**A30 Chiverton to Carland Cross
TR010026**

**8.15 COMMENTS ON INTERESTED
PARTY SUBMISSIONS AT DEADLINE 2**

Volume 8

April 2019

Location: **-DR-ZL-000405** | Type: **-** | Role: **-** | Number: **-**

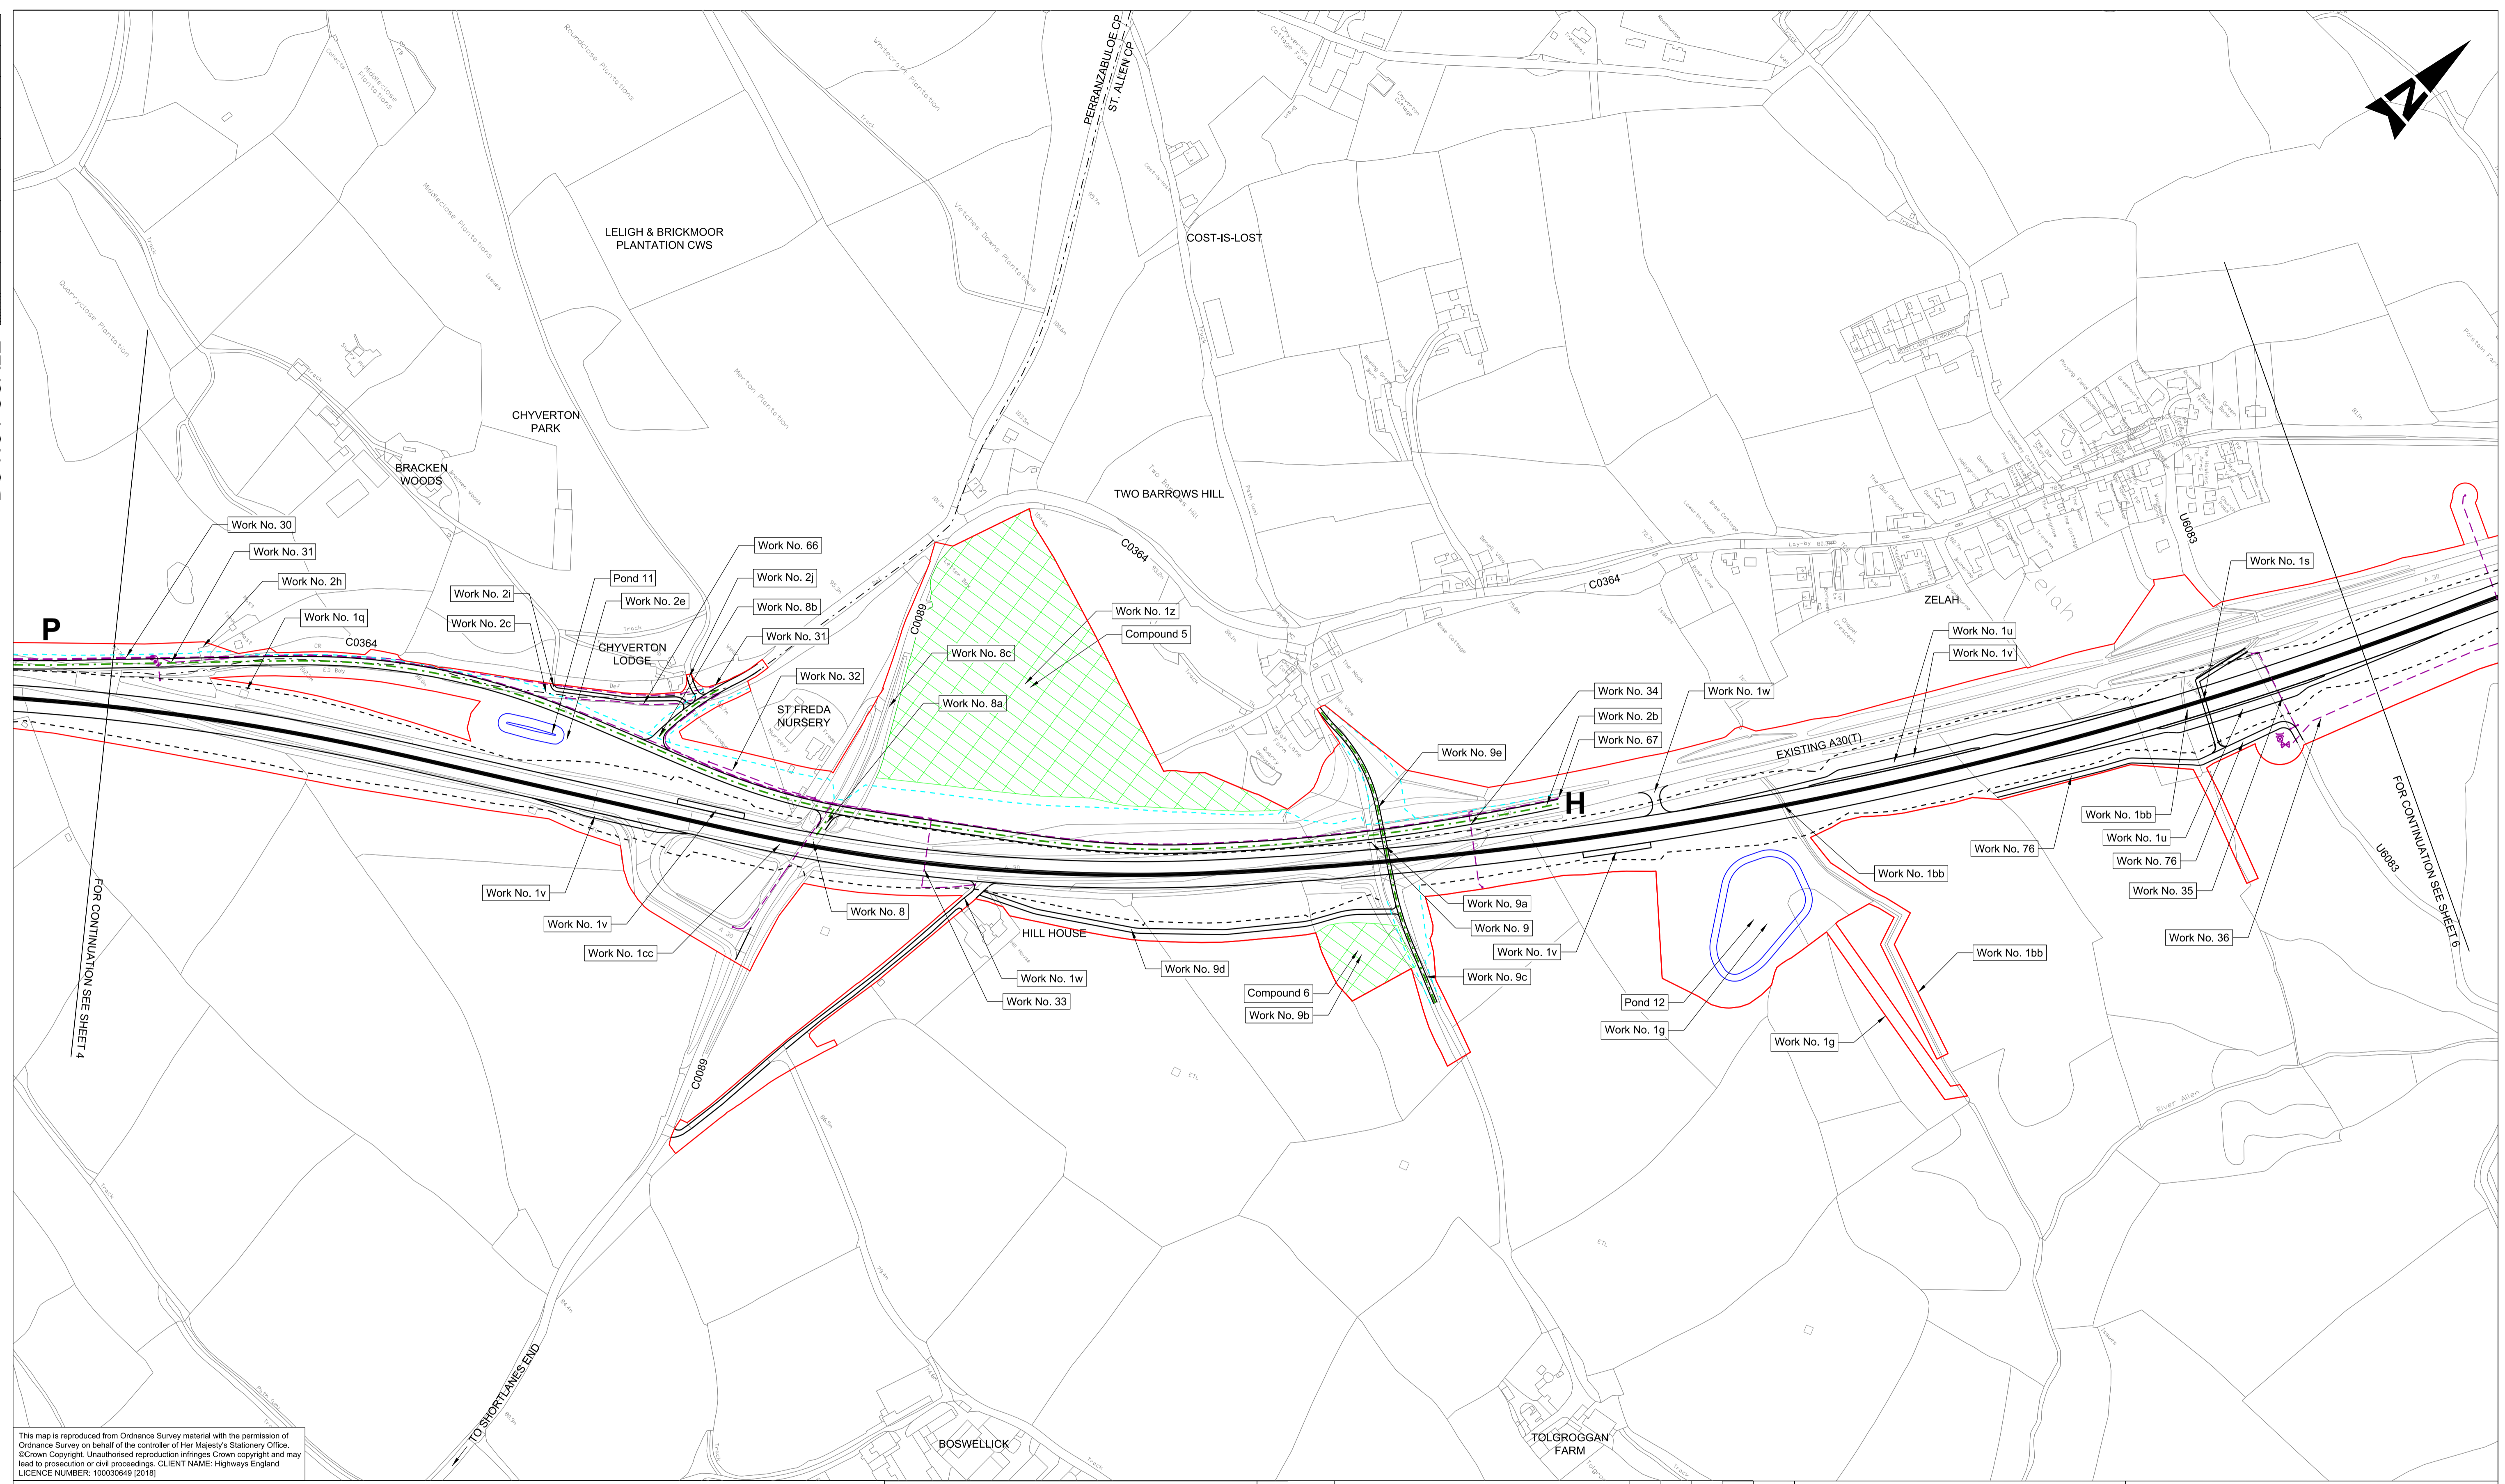
Interested Party	ExA Question	Interested Party Response to Question	Highways England Comment
			<p><i>paragraph 2.2.7 of the Details of Other Consents and Licences (Document Reference 7.2) [APP-046], applications for written consent to alter ordinary watercourses will be made as required to Cornwall Council as the Lead Local Flood Authority pursuant to section 23 of the Land Drainage Act 1991. Reference to applying to Cornwall Council for Ordinary Watercourse Consents will be retained.”</i></p>
<p>Western Power Distribution (WPD)</p>	<p>Question 1.5.13</p> <p>Paragraph 4.27 of the EM provides a list of the works (to fall under article 9 paragraph (2) of the dDCO) and persons considered to benefit. There appear to be discrepancies between the list in article 10(4) and that provided in the EM.</p> <p>Please confirm that the correct information is provided in both the EM and dDCO.</p> <p>Question 1.5.14</p> <p>Article 10 paragraph (4) of the dDCO sets out that the benefit of the Order could be transferred or leased to others by the undertaker.</p> <p>How can it be confirmed that these parties would be able to meet the CA compensation costs if the DCO permitted transfer of the CA powers and TP powers to these bodies</p>	<p>We act on behalf of Western Power Distribution (South West) PLC (WPD) whose registered office is at Avonbank, Feeder Road, Bristol, BS2 OTB. We note the Examining Authority's first written questions issued on 13 February 2019 and confirm that WPD have raised the same questions as the inspector which are referenced at question numbers 1.5.13 and 1.5.14.</p> <p>The Applicant has responded to these questions and WPD are considering their response with a view to progressing a voluntary agreement.</p> <p>We note the deadline to register for the hearings and accompanied site inspection is Friday 22nd March 2019. WPD do not anticipate needing to attend the inquiry but please can the planning inspector hold a position should WPD's situation change.</p>	<p>As stated in the Response to the Examining Authority's Written Questions (Document Reference 8.4) [REP2-020] submitted at Deadline 2:</p> <p><i>“The Applicant has made the necessary amendments to the updated EM and dDCO submitted at Deadline 2. Both the EM and dDCO now contain the correct list of persons considered to benefit from the DCO.”</i></p> <p>A draft agreement between the Applicant and WPD has been prepared and is subject to ongoing discussion. The Applicant and WPD are currently arranging a meeting to finalise the draft agreement.</p> <p>As stated in the Response to the Examining Authority's Written Questions (Document Reference 8.4) [REP2-020] submitted at Deadline 2:</p> <p><i>“This is a precautionary provision as most statutory undertakers already have broad powers, including compulsory purchase powers, to relocate equipment themselves. However, the Applicant acknowledges that</i></p>

Interested Party	ExA Question	Interested Party Response to Question	Highways England Comment
	without further consideration by the Secretary of State?		<p><i>this point has not been dealt with expressly in this Order or previous orders.</i></p> <p><i>Subsequent to the DCO hearing, the Applicant has given further consideration to this issue. It is considered that the most straightforward solution is to expressly provide in the DCO that the Undertaker will be liable for any compensation payable on the exercise of compulsory acquisition powers by any of the transferees. Appropriate drafting has been included in the dDCO submitted at Deadline 2.”</i></p>
Nancarrow Farm	<p>Question 1.5.12</p> <p>Paragraphs 4.22 – 4.25 of the EM refer to article 8 of the dDCO, which provides for deviation laterally or vertically from the authorised development with respect to certain specified works. Although reference is made to recent example Orders where this was used, it is my understanding that in the M20 and A14 the ability to exceed the maximum limits of deviation was limited to vertical, not lateral and in the M4 no such power was set out.</p> <p>a) Would it be appropriate to exceed the vertical and horizontal limits of deviation without applying for a change to the DCO in accordance with the processes set out under the 2008 Act?</p> <p>b) Given that the limits of deviation are themselves designed to permit flexibility to deviate from the proposed scheme, what processes would be put in place for the Secretary of State to determine whether or not the development</p>	<p>Due to the particular sensitivity of our business, we would request that no lateral deviation is permitted unless it is away from Nancarrow and no horizontal deviation is permitted unless in is downwards</p>	<p>Lateral deviation is required for any reduction in the vertical alignment of the road, as this would increase the footprint of the earthworks required for the embankment in a cutting.</p> <p>Deviation upwards is restricted in the area of Nancarrow Farm, as stated in Article 8(d) of the draft DCO (Document 3.1(D)) and shown on Sheets 4 and 5 of the Works Plans (Document Reference 2.4(B)) [REP2-004 and REP2-005].</p>
